Application No: Y/68/22/L
Site Address: Berri Court Main Road Yapton BN18 0ED
Description of works: Listed building consent for the erection of detached workshop, gym/hobby and greenhouse.

Thank you for your internet representation made on 8th July 2022 which has been recorded as an objection with the comments as follows:

Title
SITE PLANS

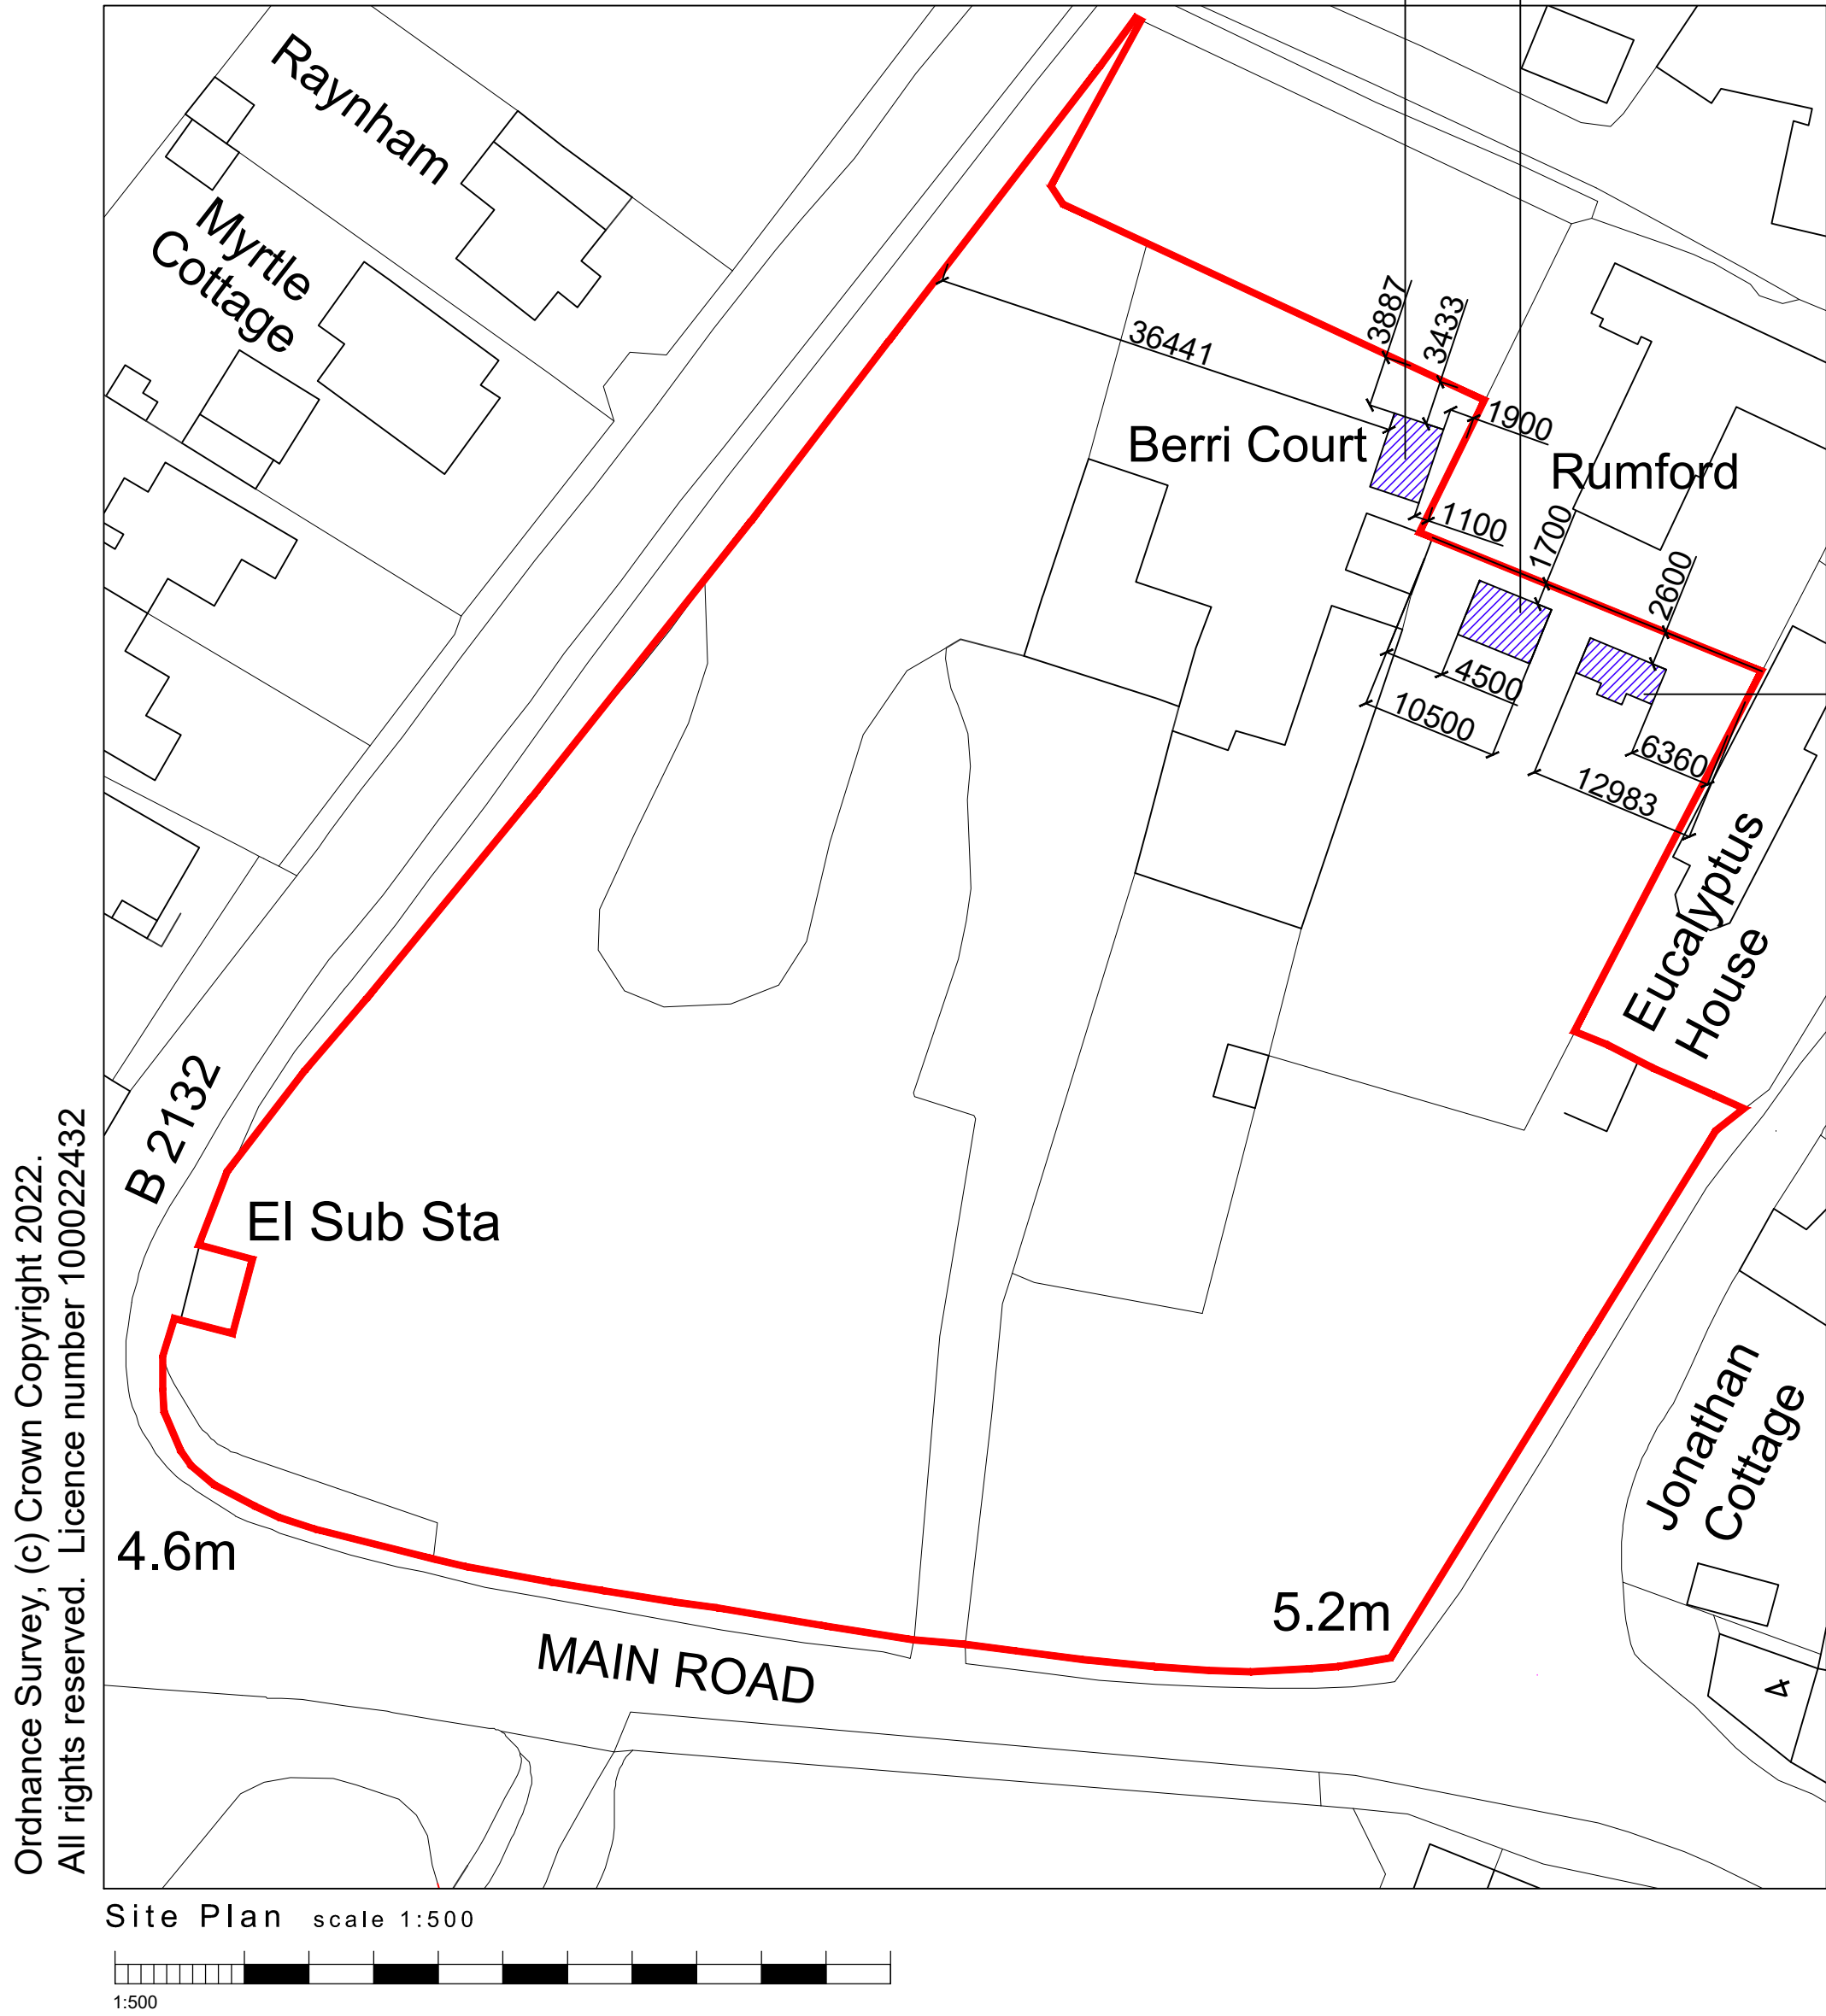
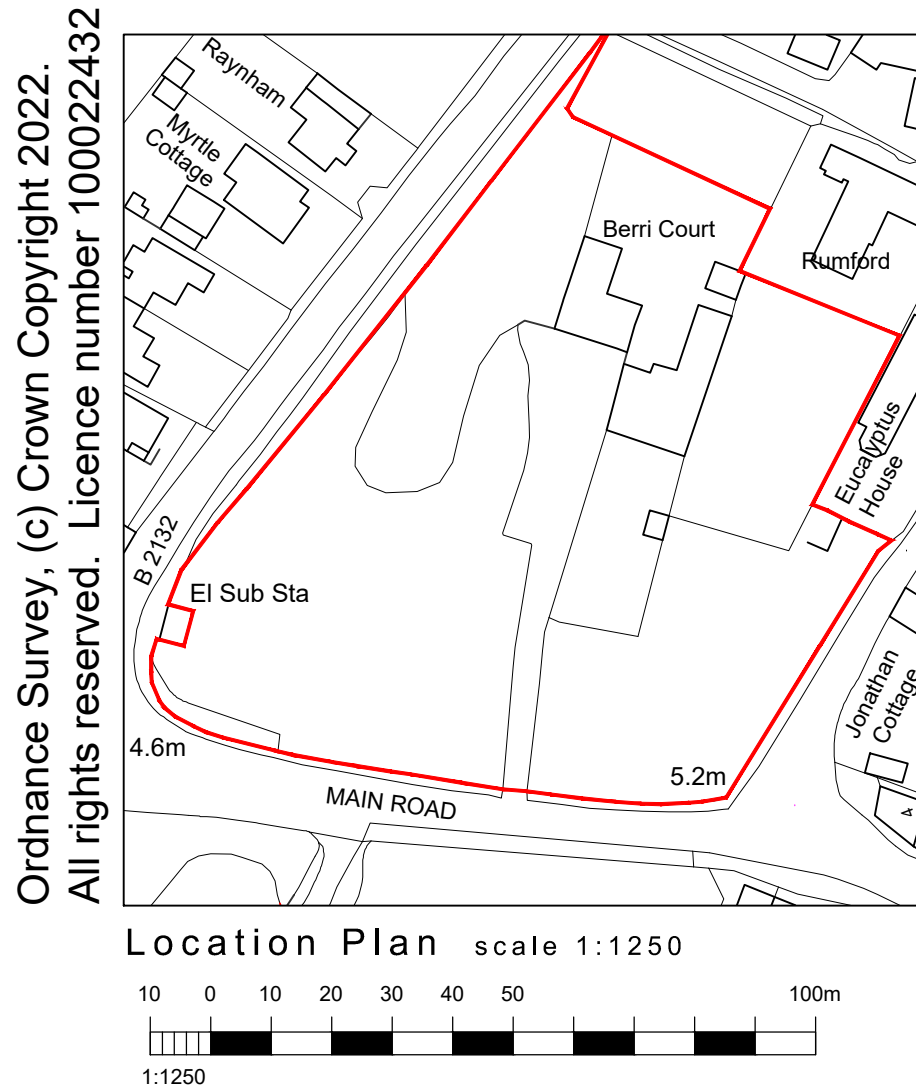
YPC whilst accepting the heritage greenhouse as acceptable in planning terms where it reflects both the listed building's heritage and that of the conservation fail to understand the compatibility in terms of design or function of the proposed adjoining workshop/hobby room.

YPC request an elevation along drawing that shows both the workshop and greenhouse and their relationship as a whole against the listed building and its setting. YPC would ask that this application be deferred until such a drawing is issued.

YPC object to the application in its current form and would seek that the workshop/hobby room is removed in its entirety from any proposal that may be considered currently or in the future.
